Plymouth Engineering, Inc.

Project No. 16055

Response to Comments – 7-Unit Building, 30 Merrill Street, Portland, Maine

PROJECT NAME: SIX-UNIT BUILDING 30 MERRILL STREET
 PORTLAND, MAINE
 SHEET NAME: SITE LAYOUT PLAN

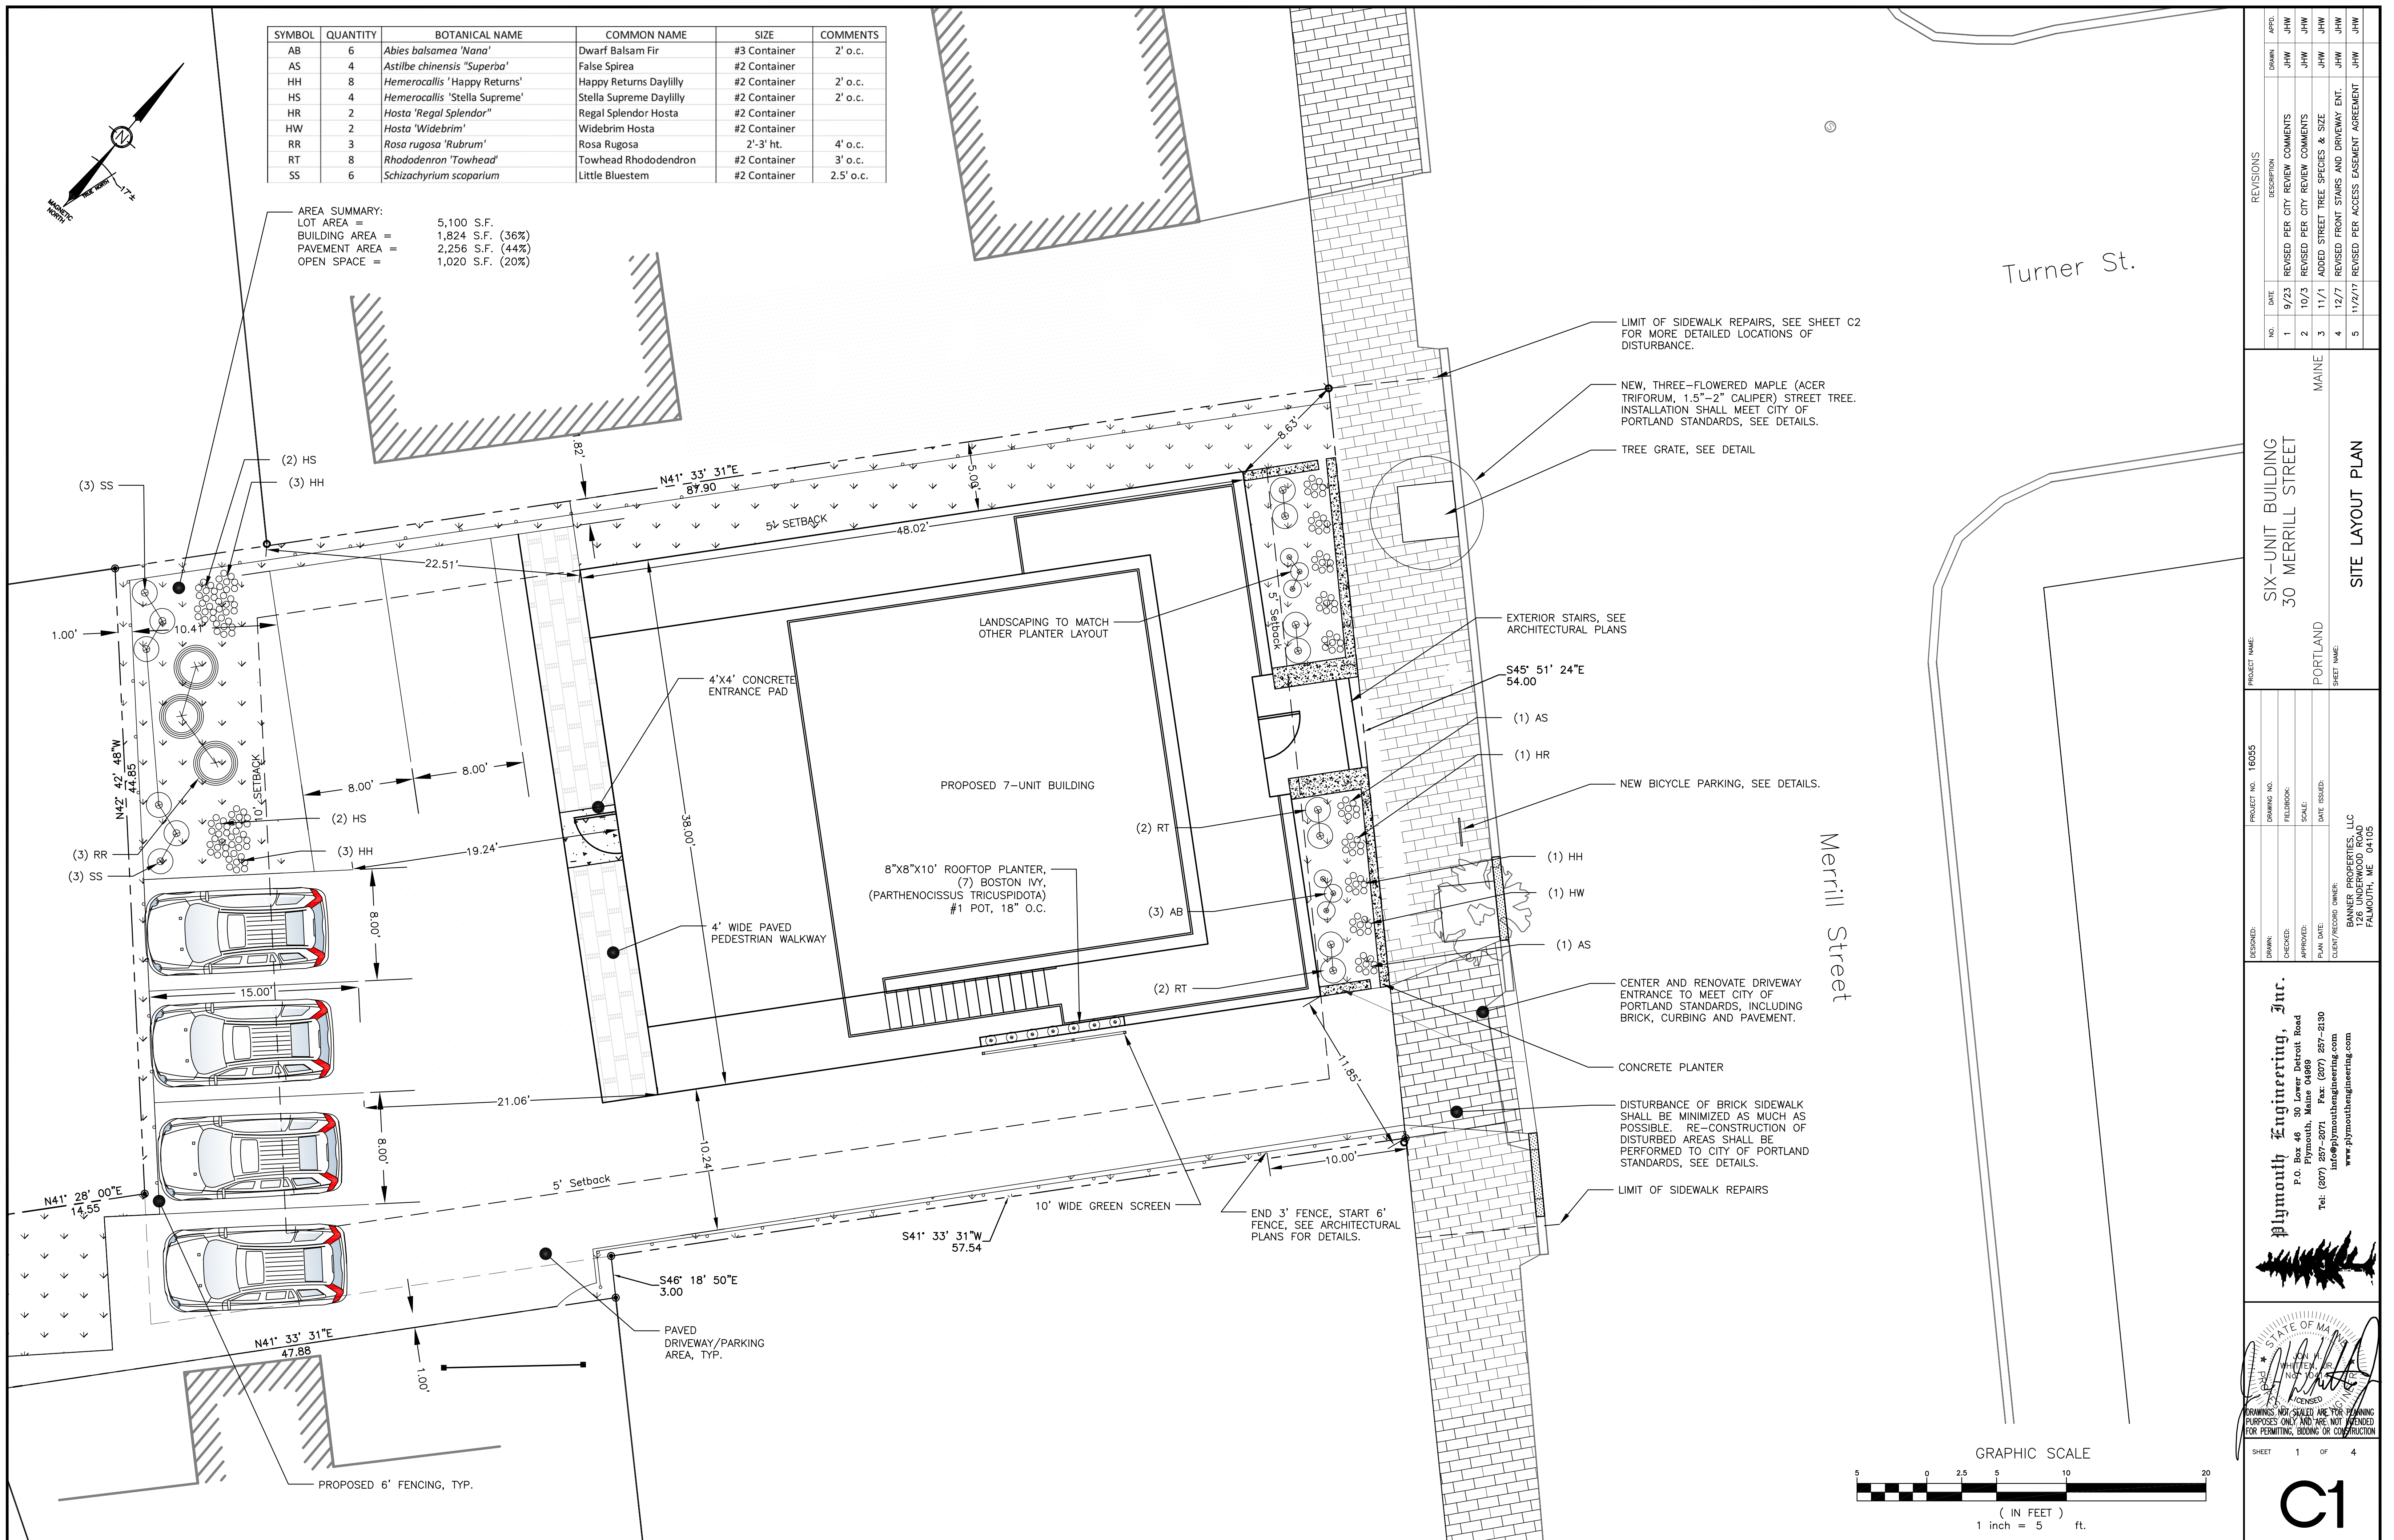
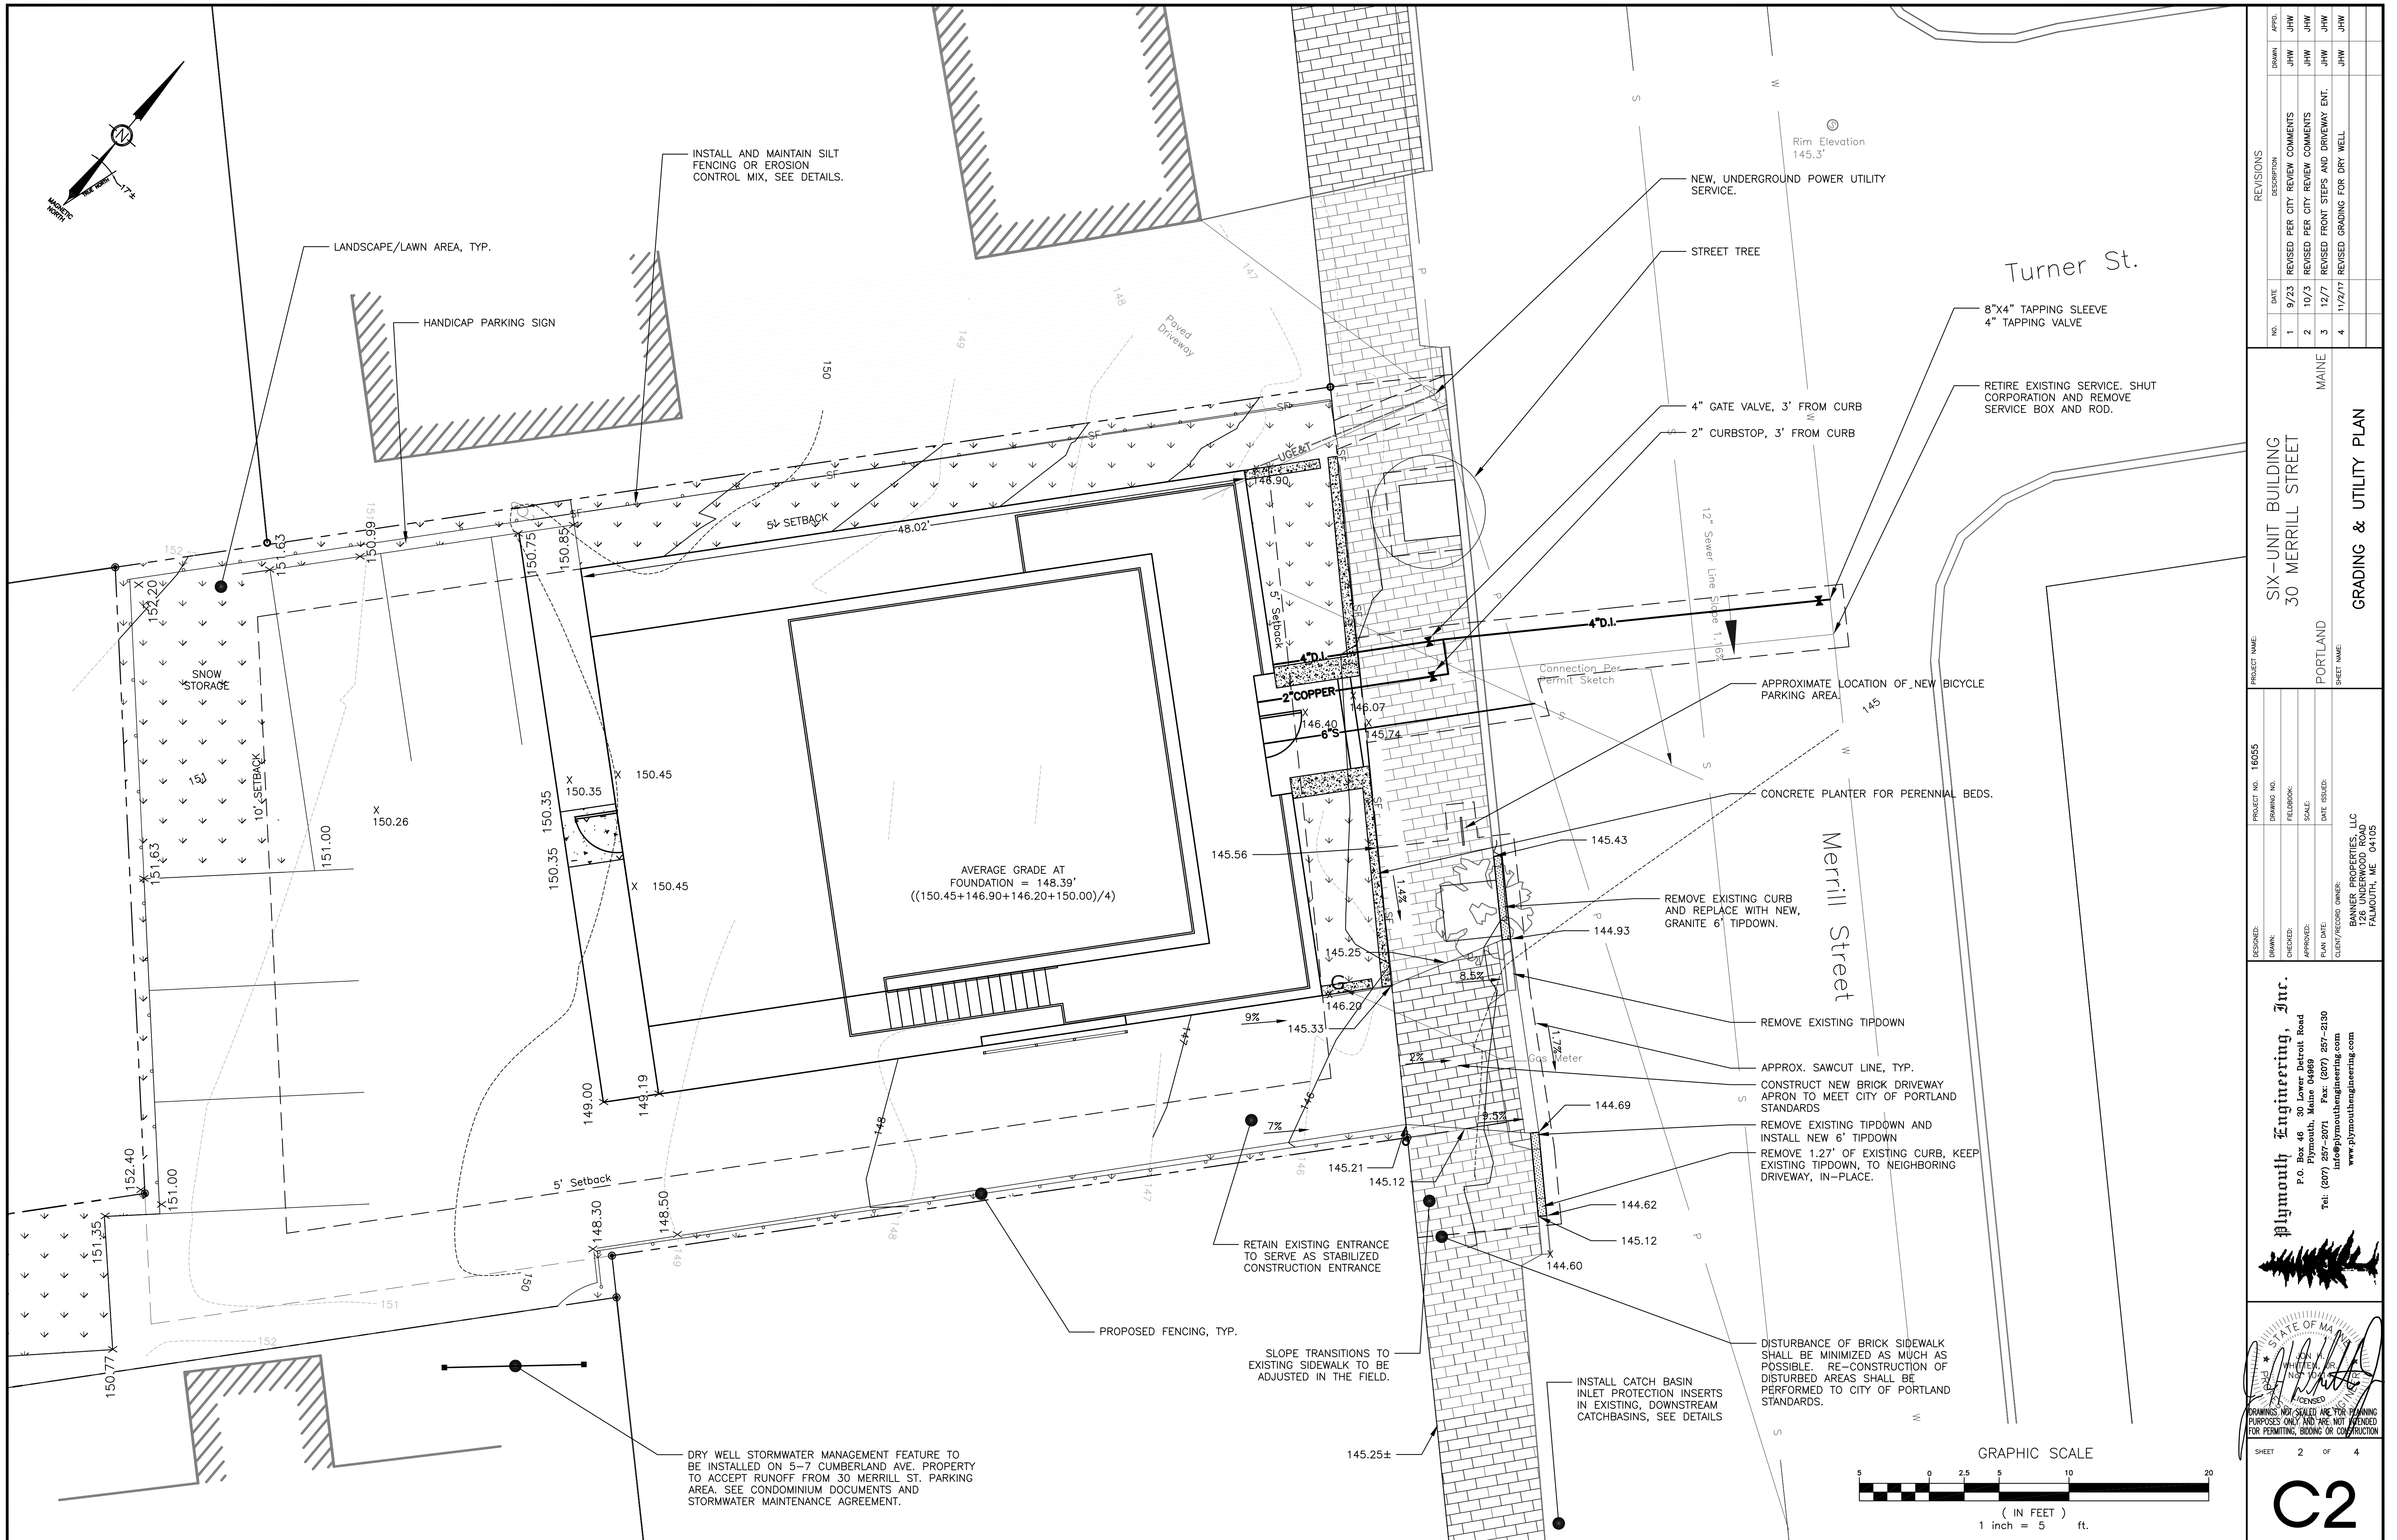
- Addition of a Landscape List on Sheet C1,
- Removal of the parking space closest to the building, adjacent to the Handicap space,
- Moved Handicap closer to building to increase access to snow storage area in the rear,
- Addition of an alternate style of pavers next to the building to indicate a pedestrian walking area,
- Addition of a 4'x4' concrete pad at the door adjacent to the parking lot,
- Note to center and renovate the brick driveway entrance and granite curbing for the site, and
- Note on the Pervious Paver Detail (Sheet C4) to indicate a potential need for an impervious liner if separation from bedrock cannot be achieved on the site,
